OAKLANDS FARM SOLAR PARK

Applicant: Oaklands Farm Solar Ltd

The Applicant's Comments on Written Representations and other
Deadline 1 submissions

Document Ref: EN010122/D3/11.2

Trailer of HGV enters opposing lane on turn due to the angle of the bend.

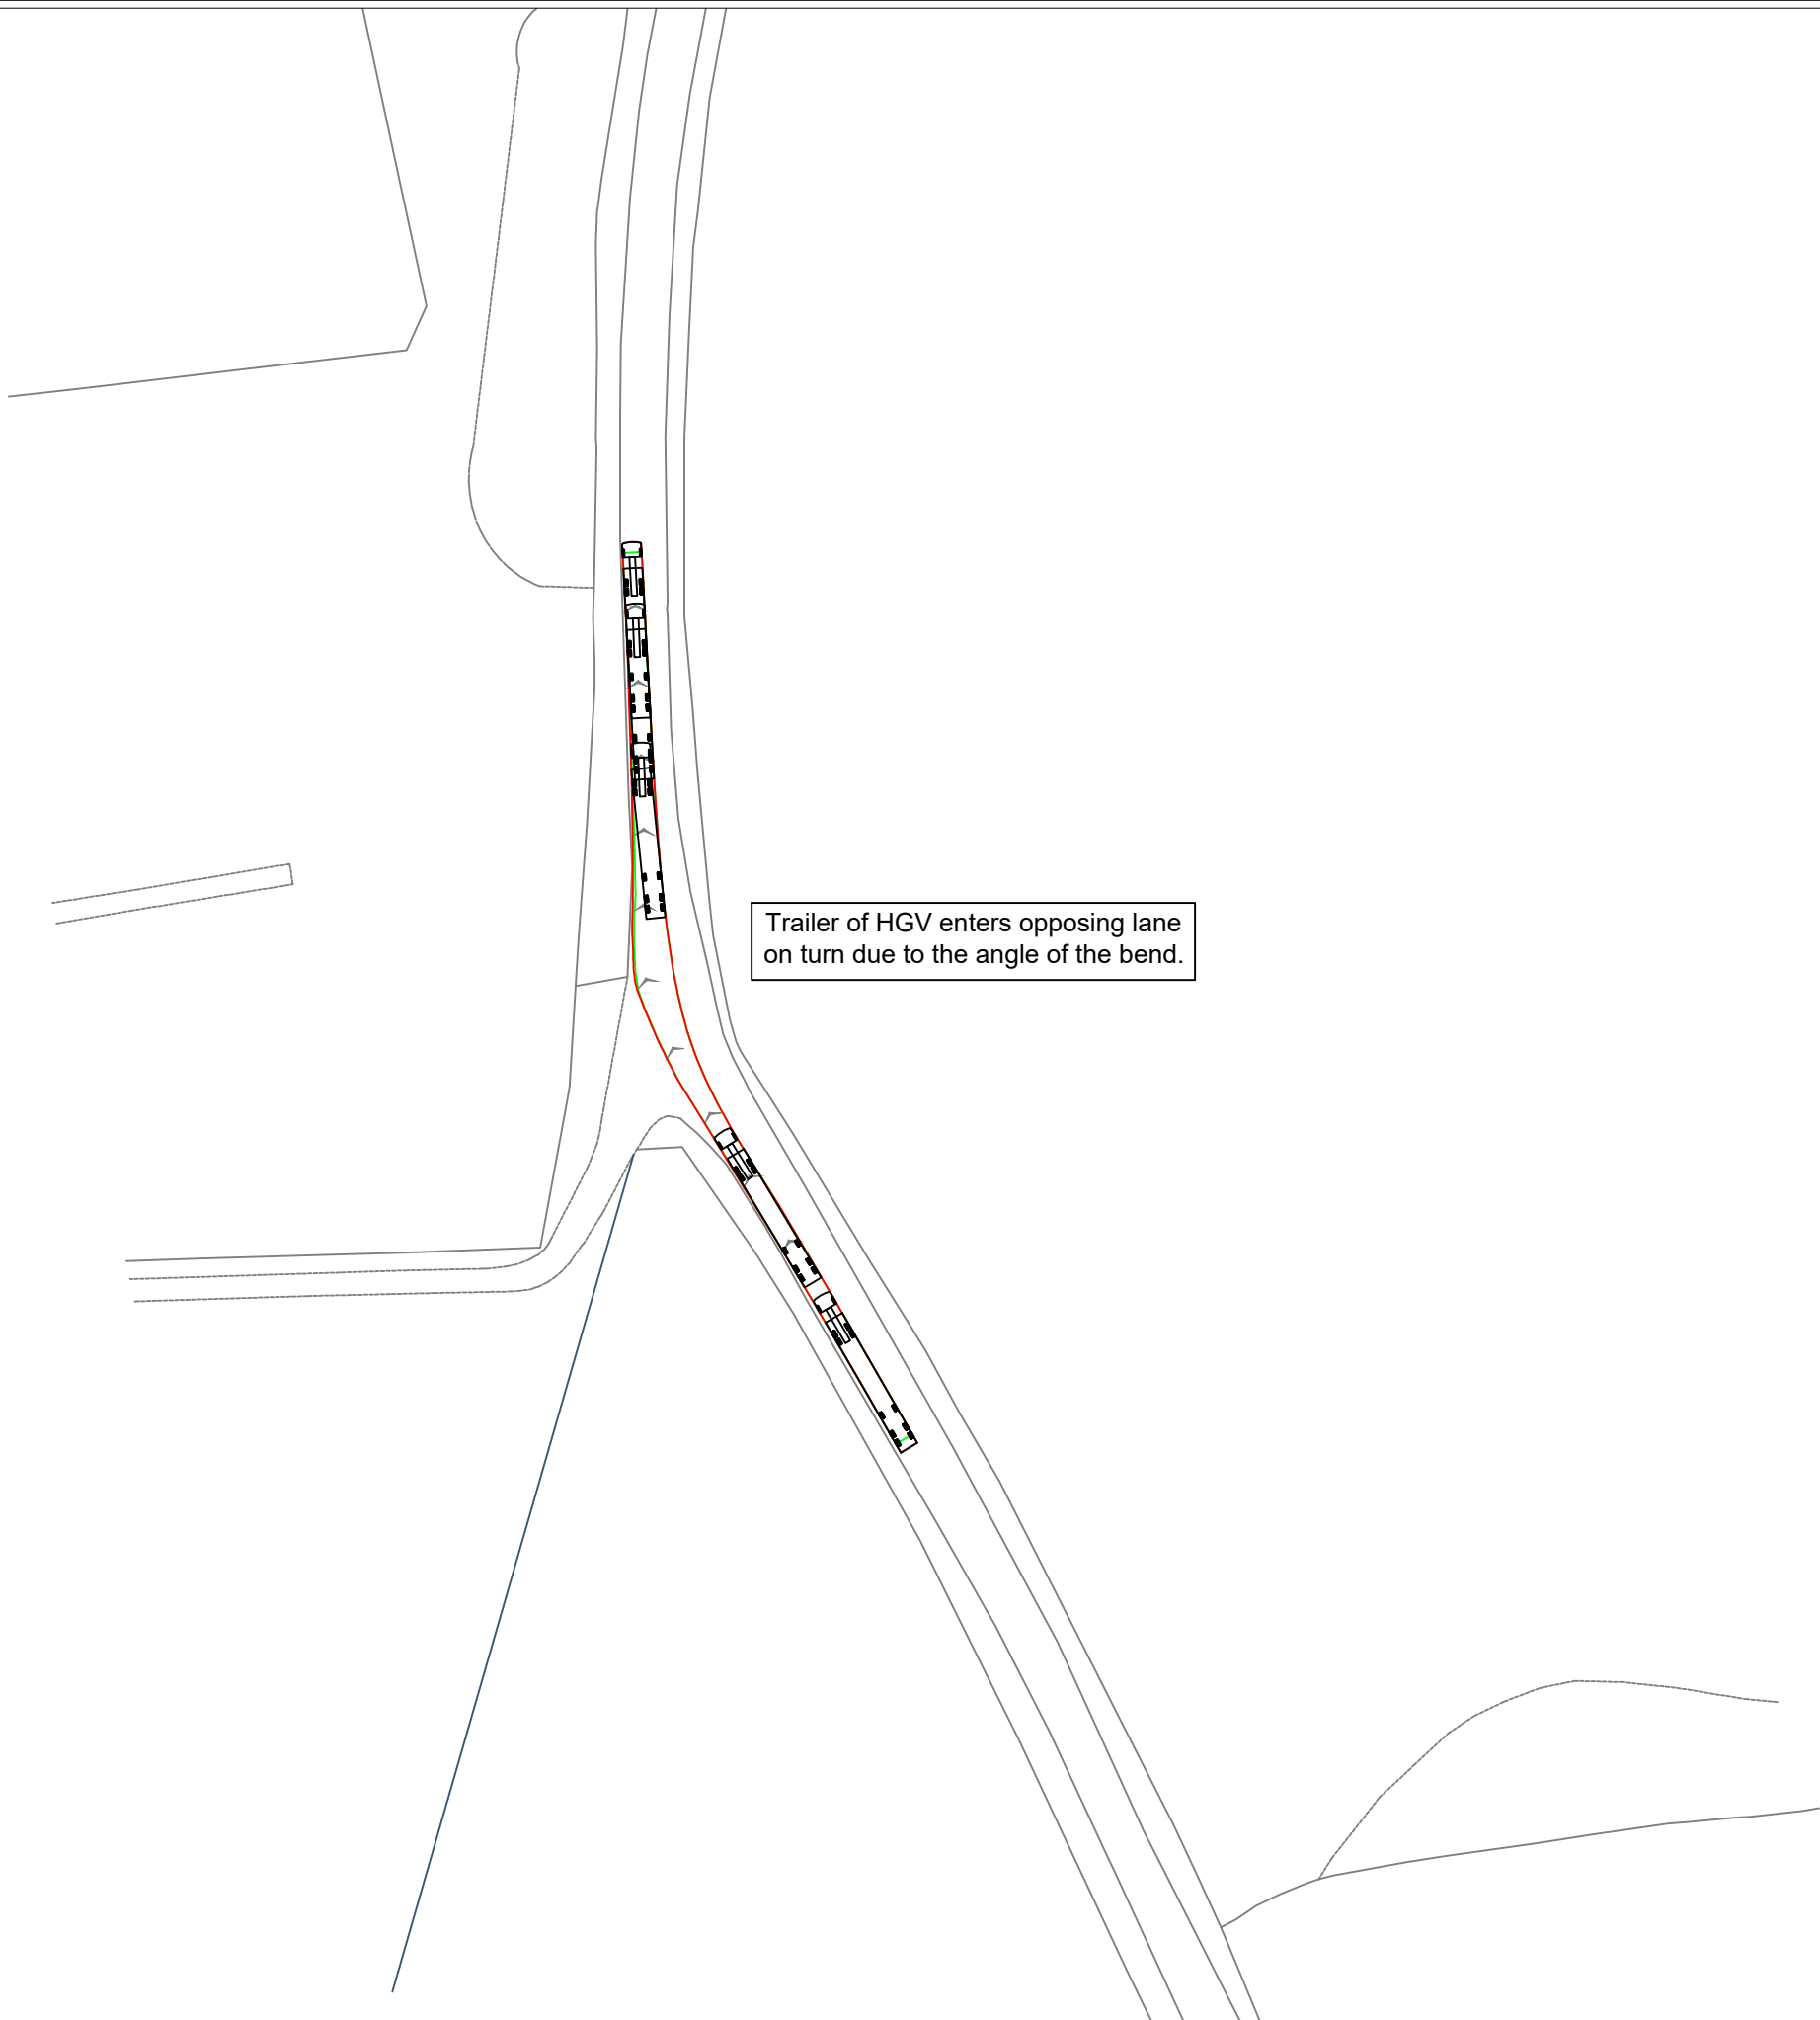
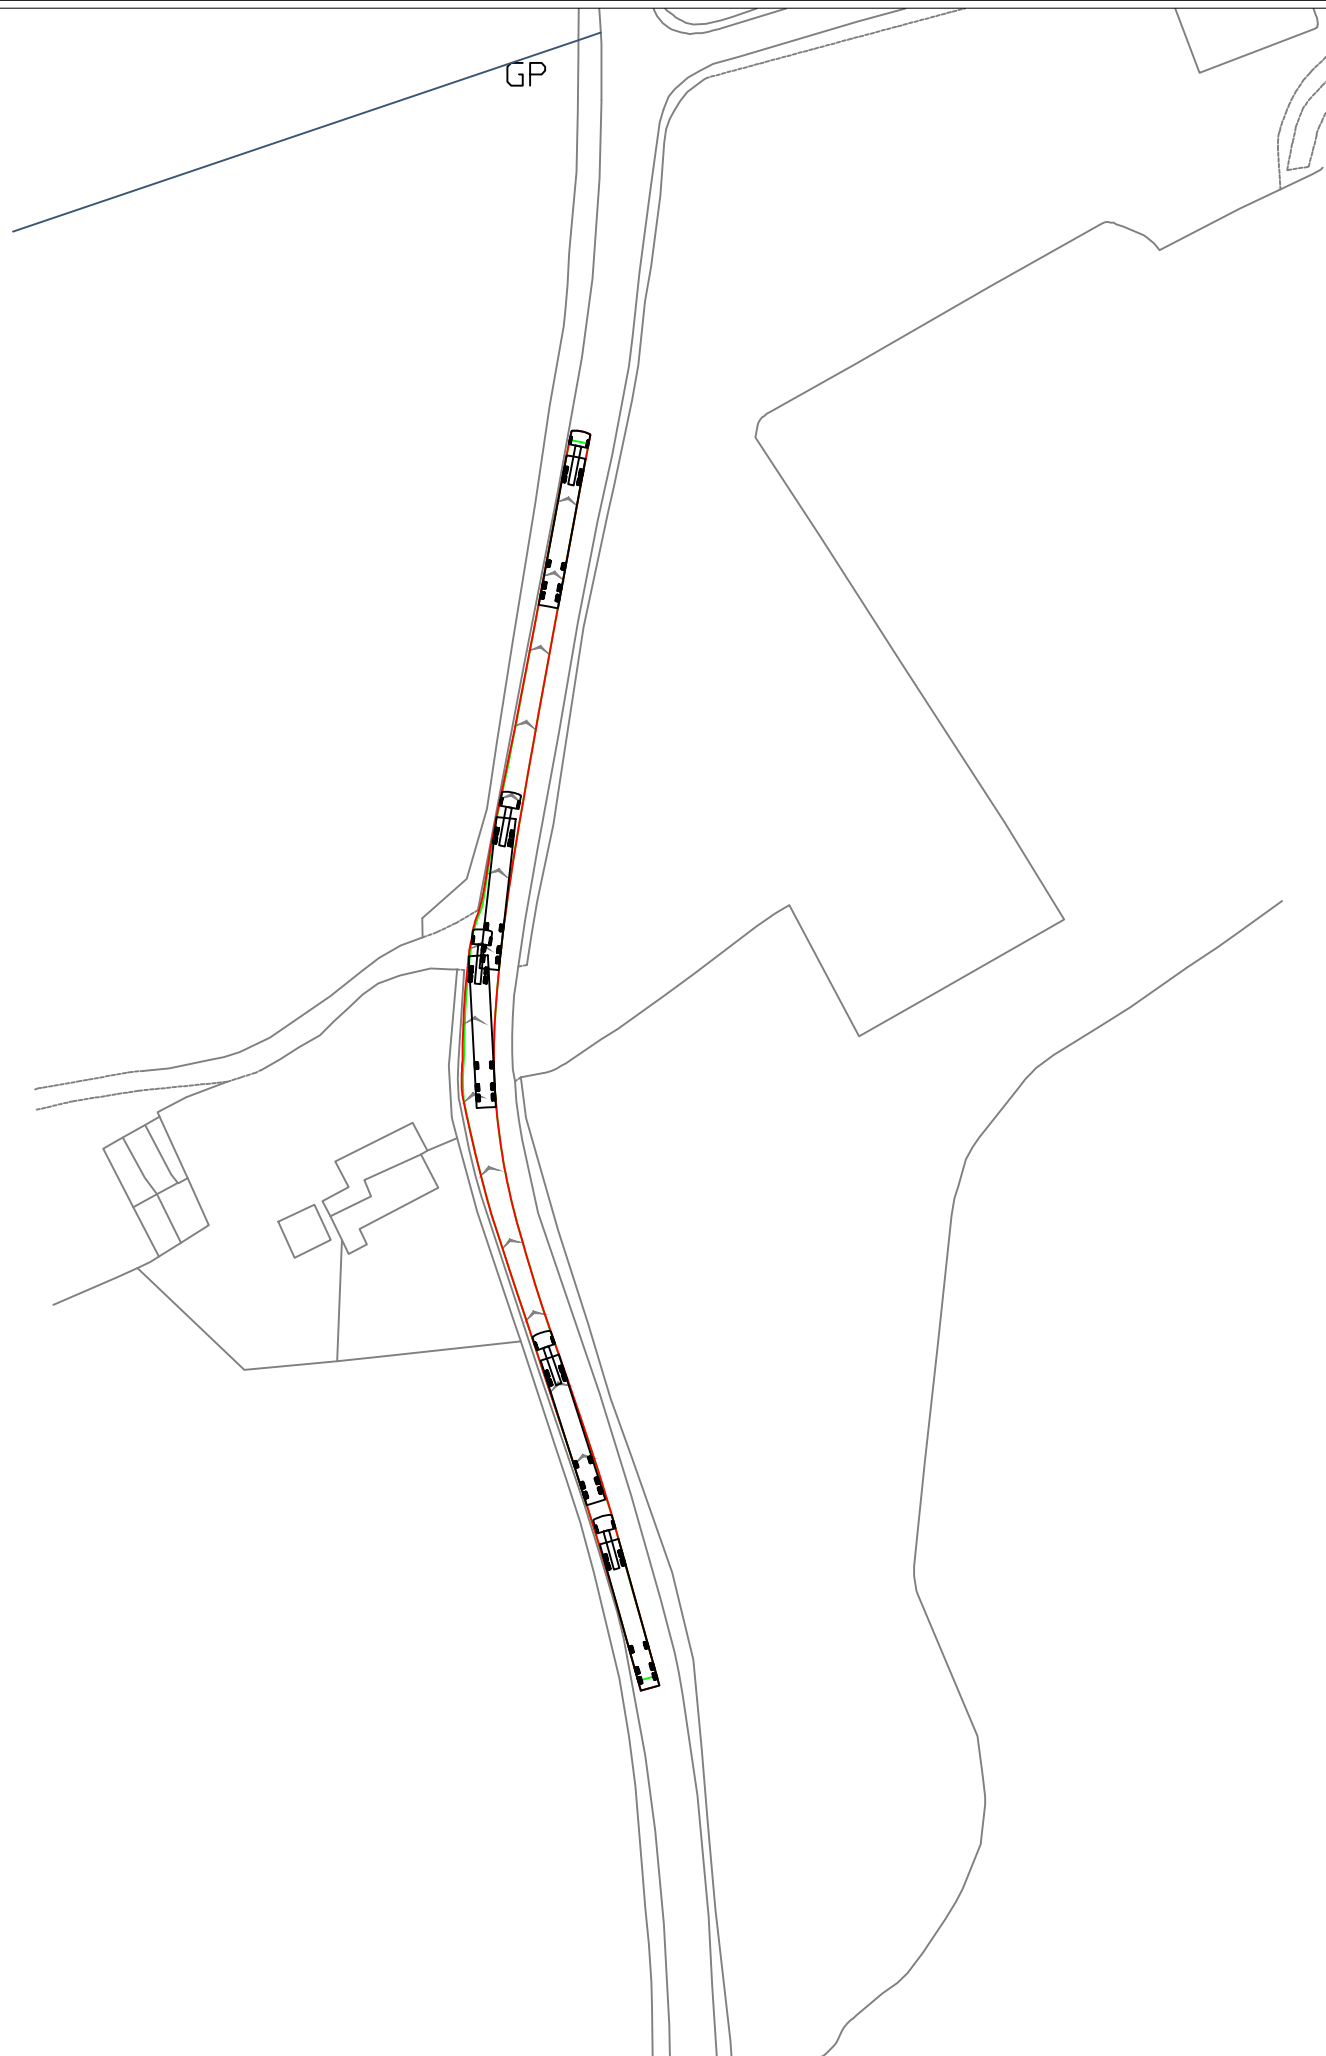
THEME	COMMENT	APPLICANT RESPONSE
Transport	<p>The submitted Environmental Statement (APP-155) states that AIL are proposed to use the Leicestershire Local Road Network (LRN) (A444) between the M42 and Acresford. Whilst these AIL movements are predicted to be limited in number to two (APP155, paragraph 10.154), and are proposed to be Police escorted (APP-155, paragraph 10.156), the submission identifies that surface protection, culvert reinforcement, and temporary removal of street furniture will be required at locations along the route (APP-155, paragraph 10.157).</p> <p>However, the extent and location of such work within the public highway in Leicestershire is unclear. The supporting swept path analysis (APP-154) of which drawing numbers DWG/3299/001 - DWG/3299/005 are relevant to Leicestershire, is labelled as indicative and includes a drawing note which simply states, 'specific vehicle configuration to be checked by specialist haulage company'. Furthermore, the drawings do not appear to be based on a topographical survey and therefore don't identify street furniture etc; neither do they indicate locations of structures e.g., culverts.</p> <p>LCC therefore request that the Applicant engages at the earliest opportunity within this Examination process and confirms the vehicle specification, the associated highway impacts, and the necessary mitigation measures on the LRN in Leicestershire.</p>	<p>The Chapter 10 (Transport and Access) of the Environmental Statement (ES) [APP-155] has assessed the environmental effects for Abnormal Indivisible Loads (AIL). Abnormal load mitigation measures will be secured under Requirement 10 (construction traffic management plan) of the Draft Development Consent Order (dDCO) [REP1-003] in a detailed Construction Traffic Management Plan (CTMP). There is also a legal requirement on the Applicant under the Electronic Service Delivery for Abnormal Loads (ESDAL) system to provide mitigation.</p> <p>The AIL movements will be subject to a separate application and permitting scheme, currently administered by National Highways in consultation with the relevant highway authorities and police. This process will be supported by additional route assessment and validation, including additional surveys as required. Arrangements for further consultation, liaison and monitoring are included in the Outline Construction Traffic Management Plan (OCTMP) [REP1-021].</p> <p>The details of the AIL movements will be confirmed at the detailed design stage once the vehicle specifications are known and the extent of the AIL can be fully assessed in detail. As set out in the OCTMP suitable mitigation measures that will be provided, include:</p> <ul style="list-style-type: none"> • Advanced notification of AIL movement to local residents and businesses. • Temporary Traffic Regulation Order to ensure route remains unobstructed of parked vehicles. • Movement undertaken at a specific time of day in a rolling roadblock format, supported by a police escort to limit the magnitude of impact on identified sensitive receptors. • AIL supported by an escort vehicle along the entirety of its route to warn vehicles and allow the AIL enough time to navigate bends and turns.

<ul style="list-style-type: none"> • Suitable reinforcements of identified culverts within Coton in the Elms, informed by a DCC approved structural engineer report. • Surface padding to protect any areas of overrun including kerbs and verges. <p>The Applicant will be engaging further with LCC during the course of the Examination regarding the detailed CTMP and AIL Swept Path Analysis.</p>
Transport	The Applicant should be aware that the A444 is a Diversion Route for Unplanned Events (DRUE) on the Strategic Road Network (M42) and consideration should be given when planning and programming abnormal load movements.	The Applicant welcomes this comment and will ensure this is included in the detailed CTMP.
DCO	LCC seeks protection of its assets and recovery of any associated costs through provisions within the Development Consent Order. The draft as submitted (APP-016) does not appear to contain the necessary provisions. Indeed, no reference is made to Leicestershire.	The Applicant is required to remediate any damage to the highway network under the CTMP secured by Requirement 10 of the dDCO [REP1-003] . The Applicant will continue to engage with LCC regarding its representation and will provide an update to the ExA at Deadline 4.

Transport	<p>LCC has concerns about the potential impact of AIL movements associated with this development proposal on the LRN within Leicestershire. The information submitted in support of the application is lacking in this regard.</p> <p>LCC note from our attendance at the Preliminary Meeting held on 10th July 2024 that there was a commitment from the Applicant to engaging with Interested Parties, and LCC would welcome engagement as soon as possible to address these concerns.</p>	<p>The details of the AIL movements have been fully assessed within Chapter 10 (Transport and Access) of the ES [APP-155]. The proposed mitigation is set out in the OCTMP [REP1-021] and the final detailed mitigation will be secured in the detailed CTMP as part of Requirement 10 (construction traffic management plan) of dDCO [REP1-003].</p> <p>The Applicant will be engaging further with LCC during the course of the Examination.</p>
